Subject: FW: BR/108/20/PL

BR/108/20/PL

74 London Road Bognor Regis PO21 1DD

Construction of 1 No. new second floor 2 bedroom flat over existing two storey building, additional bedroom to first floor flat, division of ground floor retail unit into 2 No units & change of use of ground floor retail space to form new access to second floor flat. This application may affect the setting of a listed building

PROJECT	London Road	DATE	12/05/20
TITLE	Proposed Plans	DRG NO	IBA/532/03
SCALE	1 : 100	REVISIONS	A

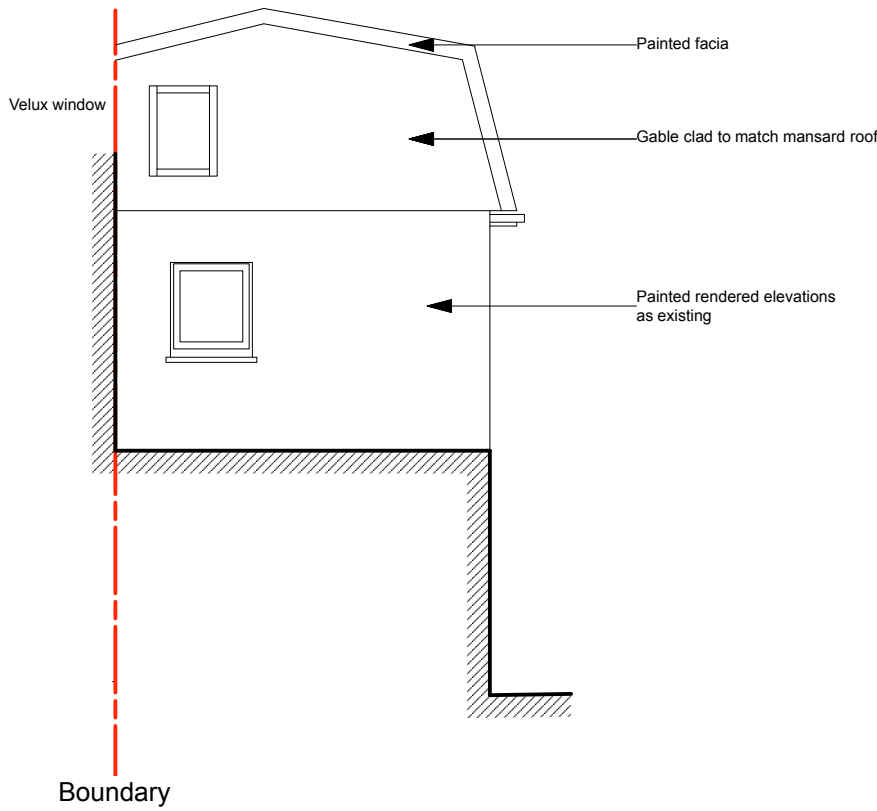
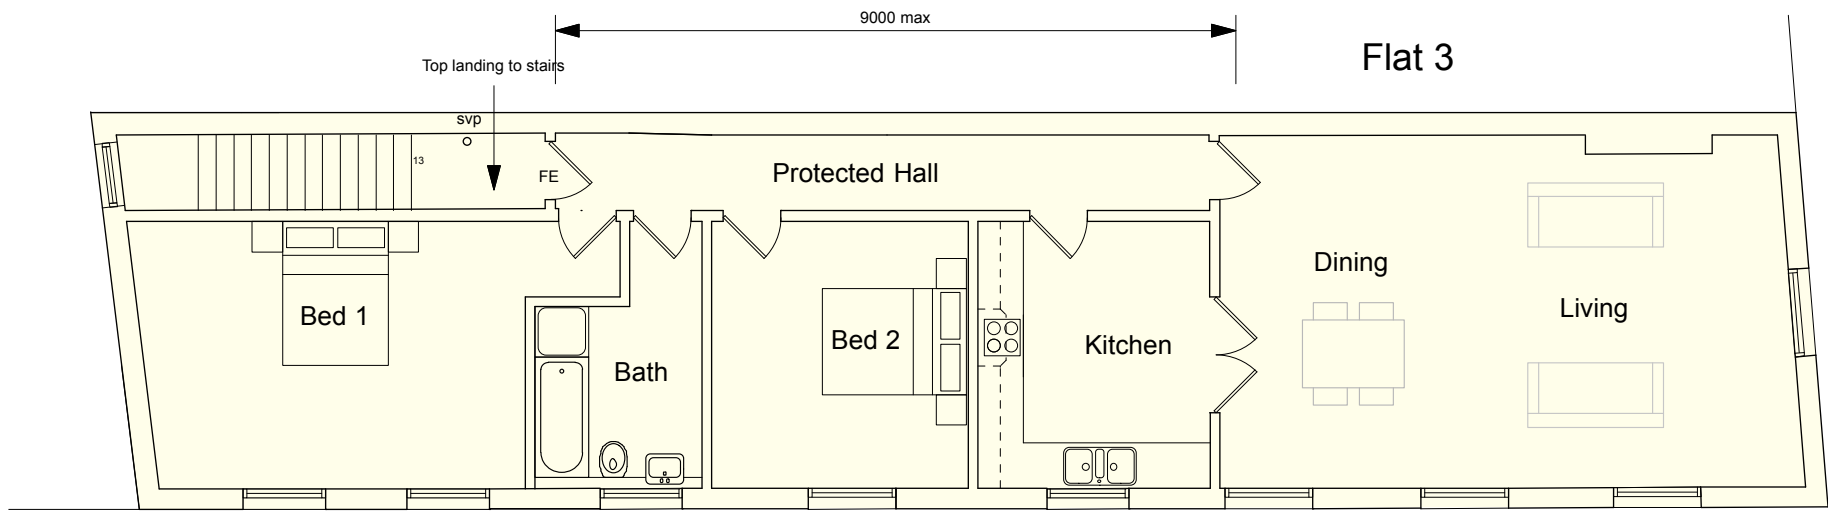
The proposal is to increase the height of the building through the introduction of an additional floor. Whilst the proposed elevations might look similar to a building on the other side of Lyon Street West, it is considered that it would affect the relationship with the immediate neighbour. This would be out of character. However, the presence of so much existing development of mixed quality will ensure that the proposal does no further harm, to the setting of the designated assets.
